Engineers Comments Regarding Surface Water Drainage

Application Reference:	R/63/26/PL	Reviewer Reference:	ADC/EXT5/AF
Planning Officer:	Simon Brookshank	Date of Review:	29/05/2026
Site Name:	The Windmill Inn and 34 Mill Lane Rustington BN16 3JN		
Application Description:	Demolition of existing Public House and 1 No dwelling and redevelopment for retirement living accommodation comprising 28 No retirement living apartments and 3 No retirement living cottages, including communal facilities, access, car parking and landscaping (resubmission following R/143/24/PL). This application is in CIL Zone 4 (Zero Rated) as other development.		
Assessment Number:	1

**Proposed Site Layout
and Positively Drained Areas Plan**

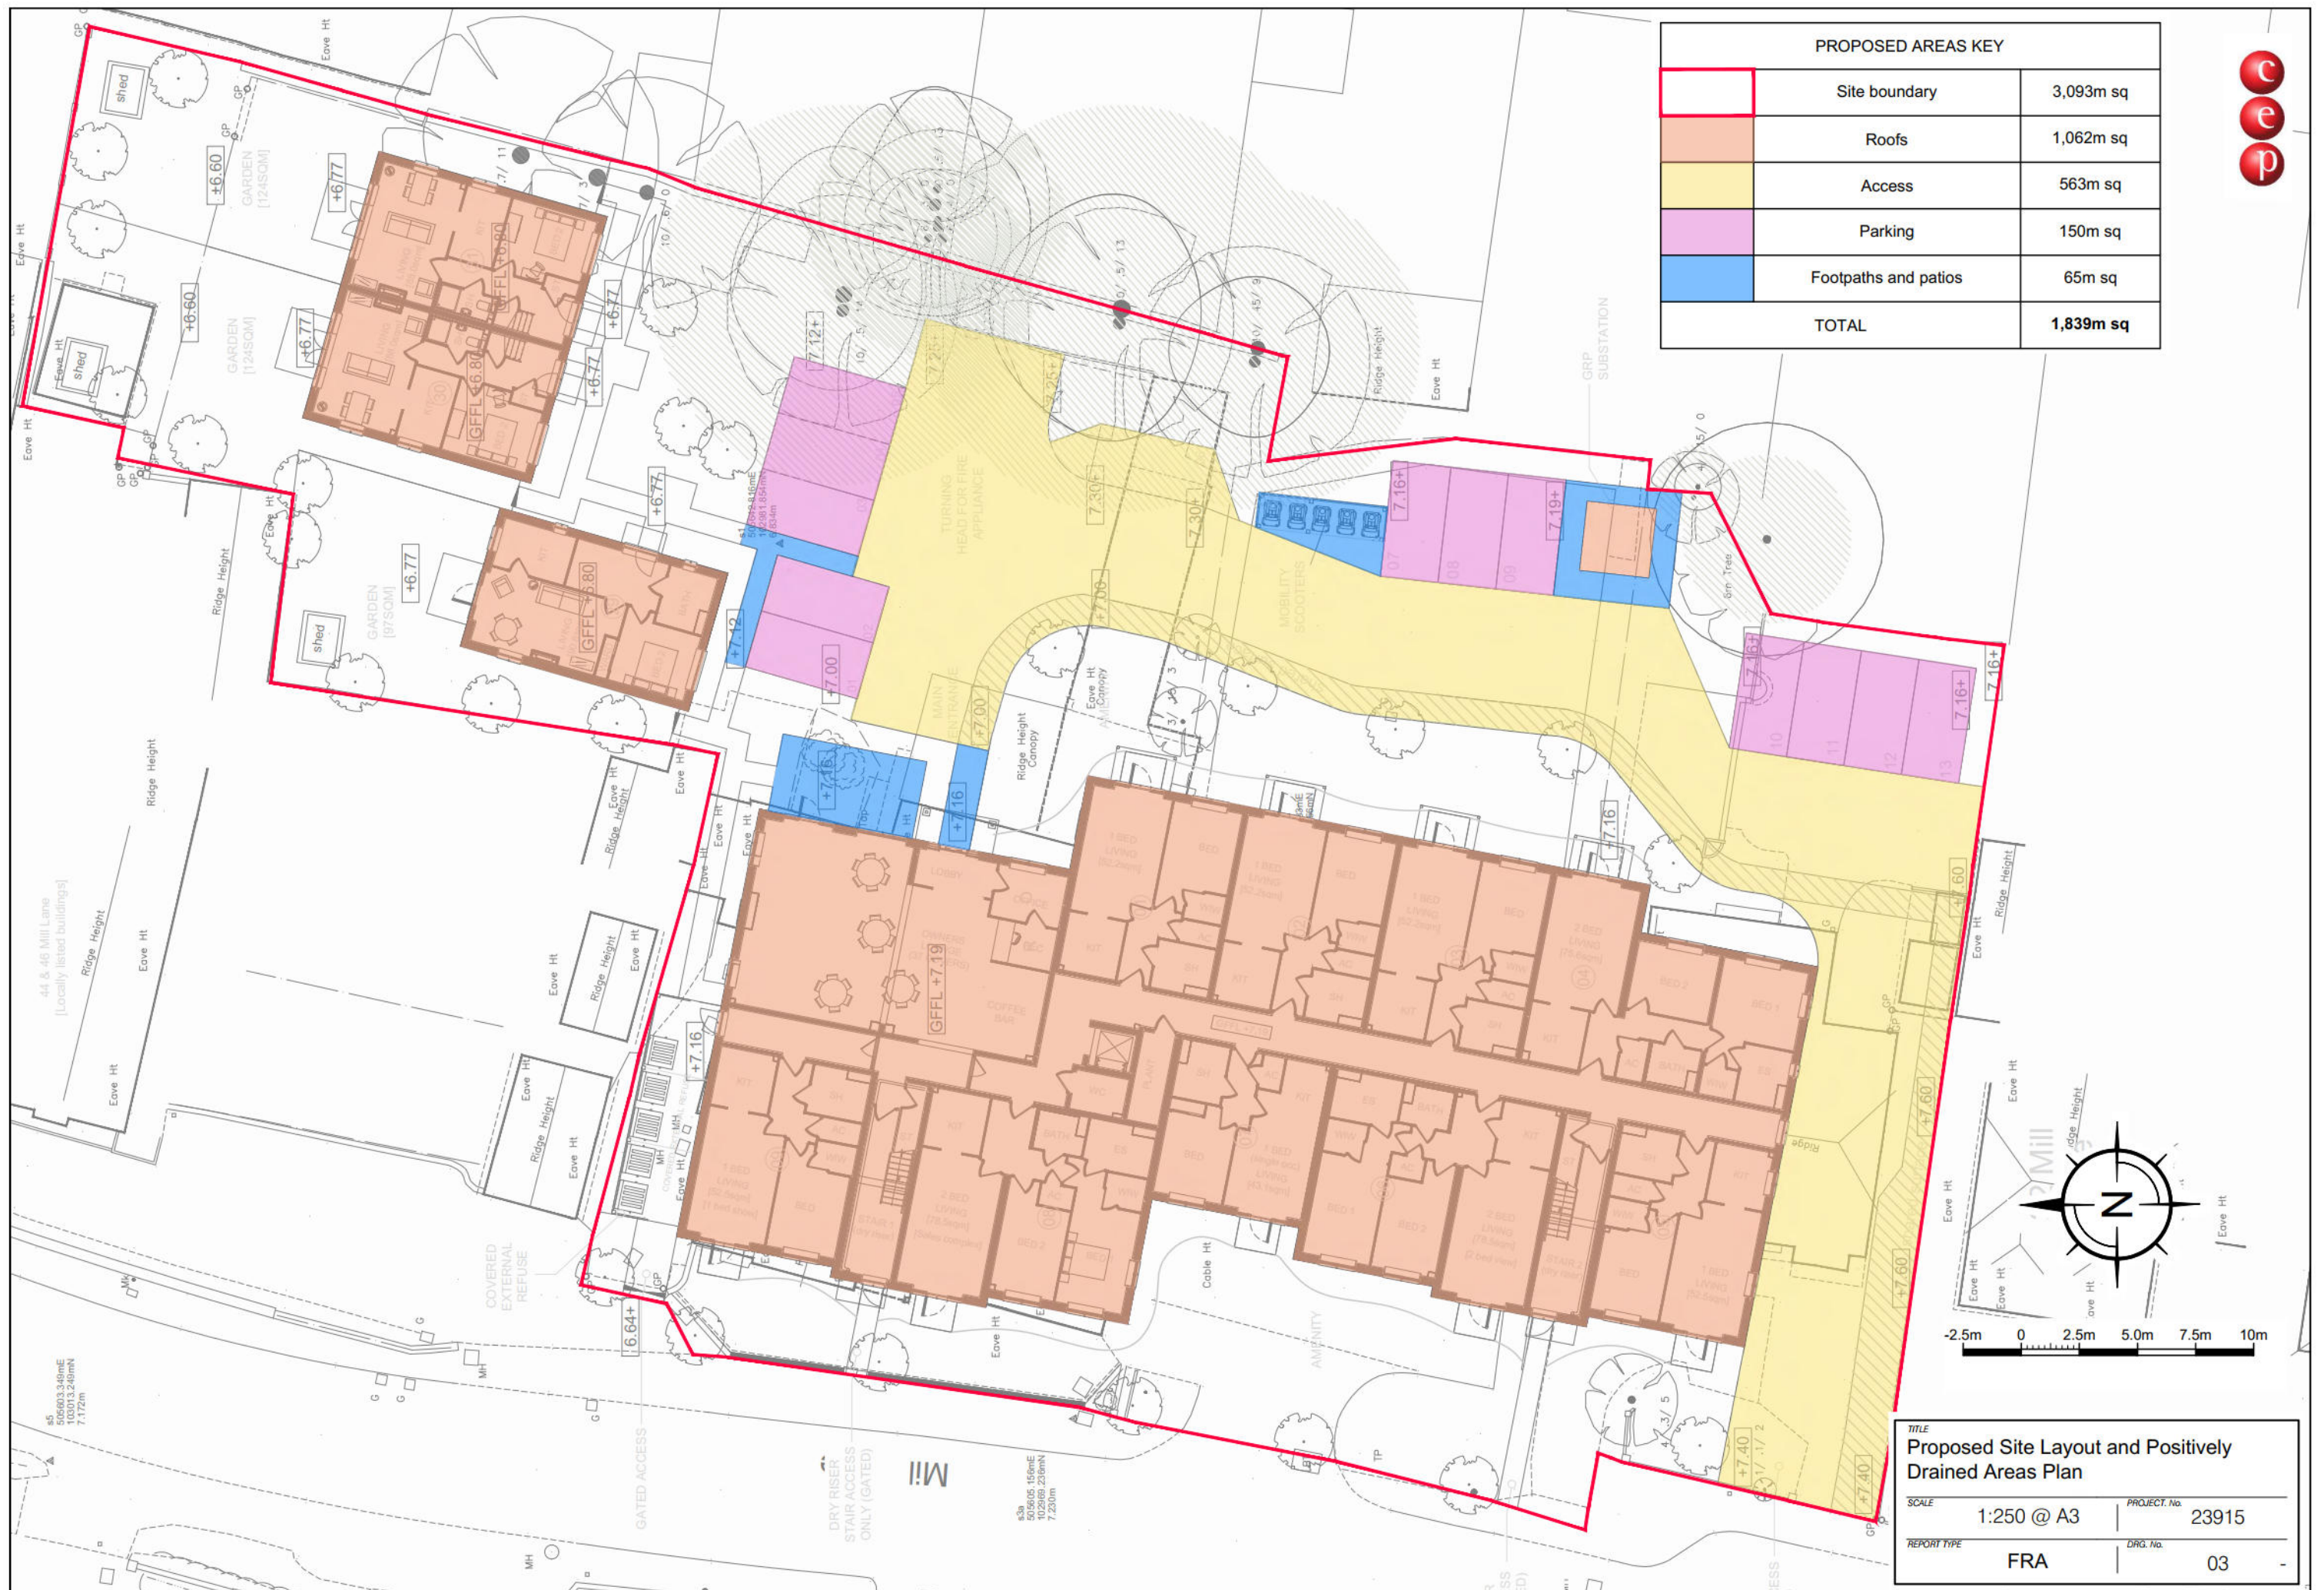
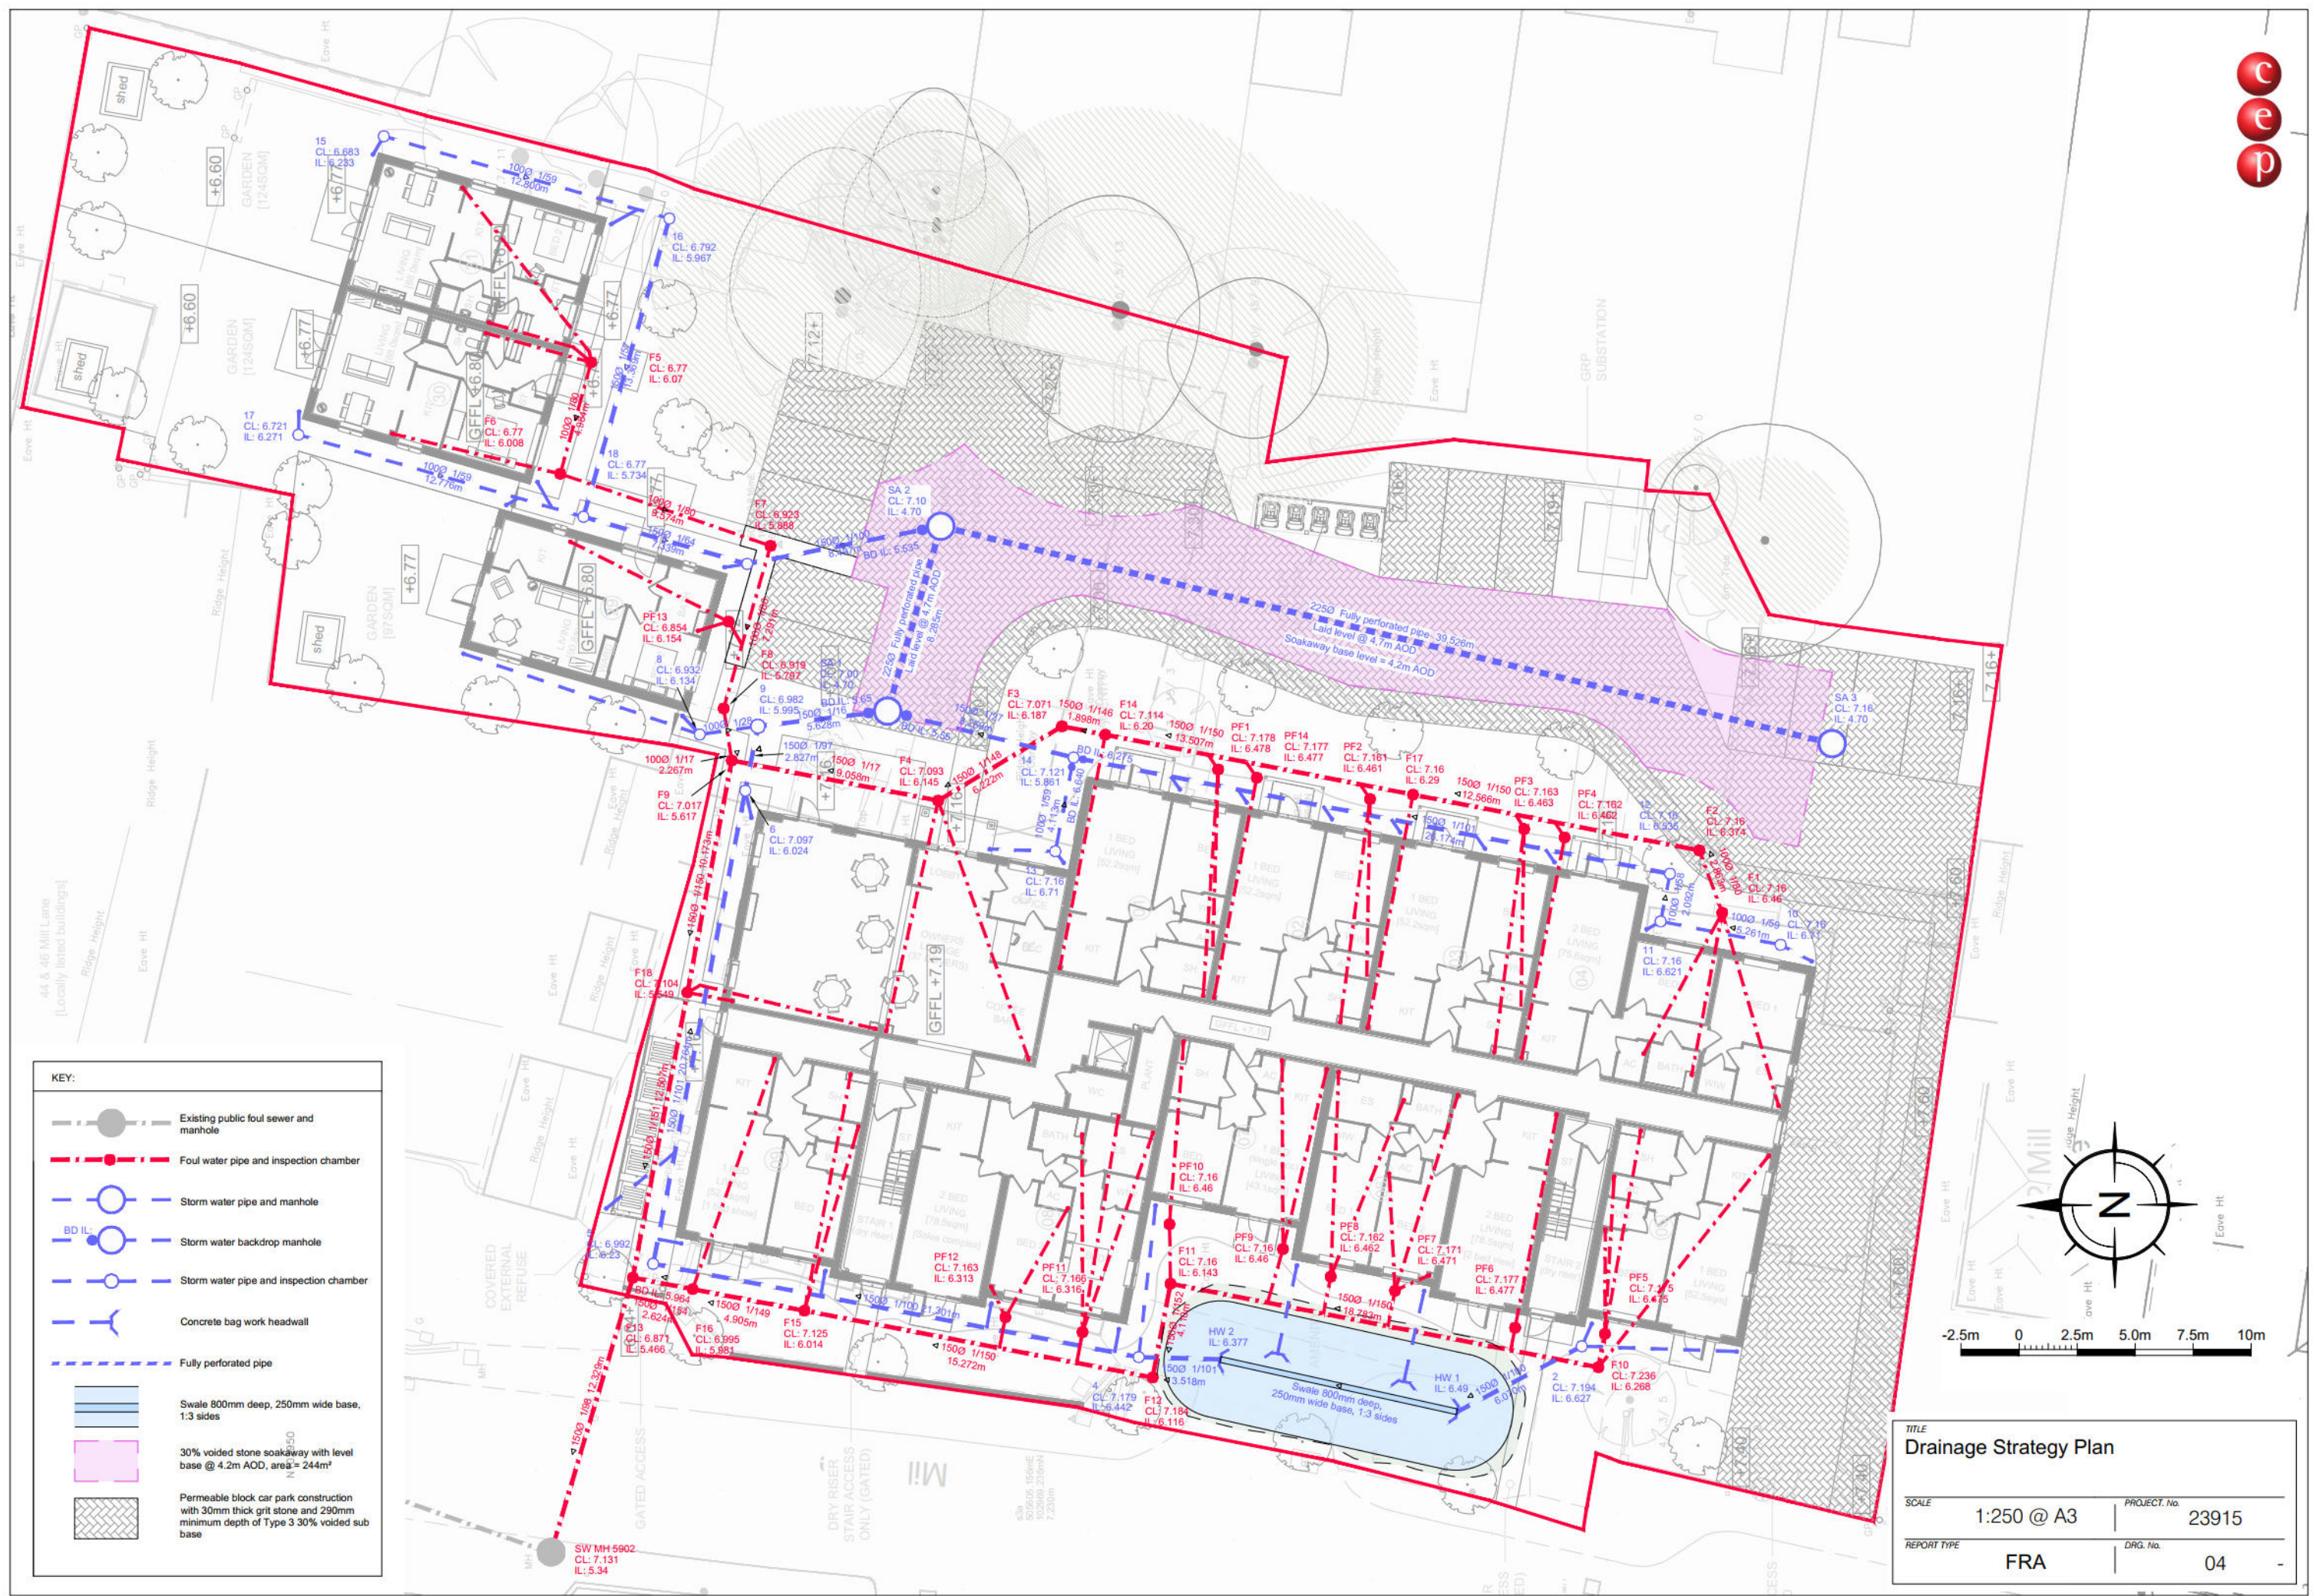
- 1.3. The groundwater monitoring (winter 25-26) shows peak readings at 3.79-3.81m AoD. The base of the proposed trench soakaway is at 4.2m AoD but the construction detail indicates an additional 200+mm could be added taking the depth to below 4.0m AoD, therefore with 200mm of winter groundwater monitoring results. The design therefore does not comply with NSfS clause 1.15 which requires a 1m vertical offset from the maximum likely groundwater level on the site.

- 3.3. The calculations show top water levels up to 1 millimetre below the lowest chamber cover during the design storm. An increased buffer should be applied.

Surface Water Exceedance Route Plan

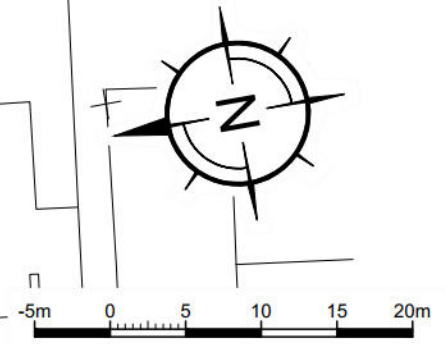
- 3.2. Exceedance paths are currently shown through fences and/or gates adjacent to buildings which may hamper the flow. However, the use of permeable pavement reduces the risk of inlet capacity being exceeded and the low point in the drainage system is covers in the rear gardens at the northern end. The exceedance paths plan should be clarified.
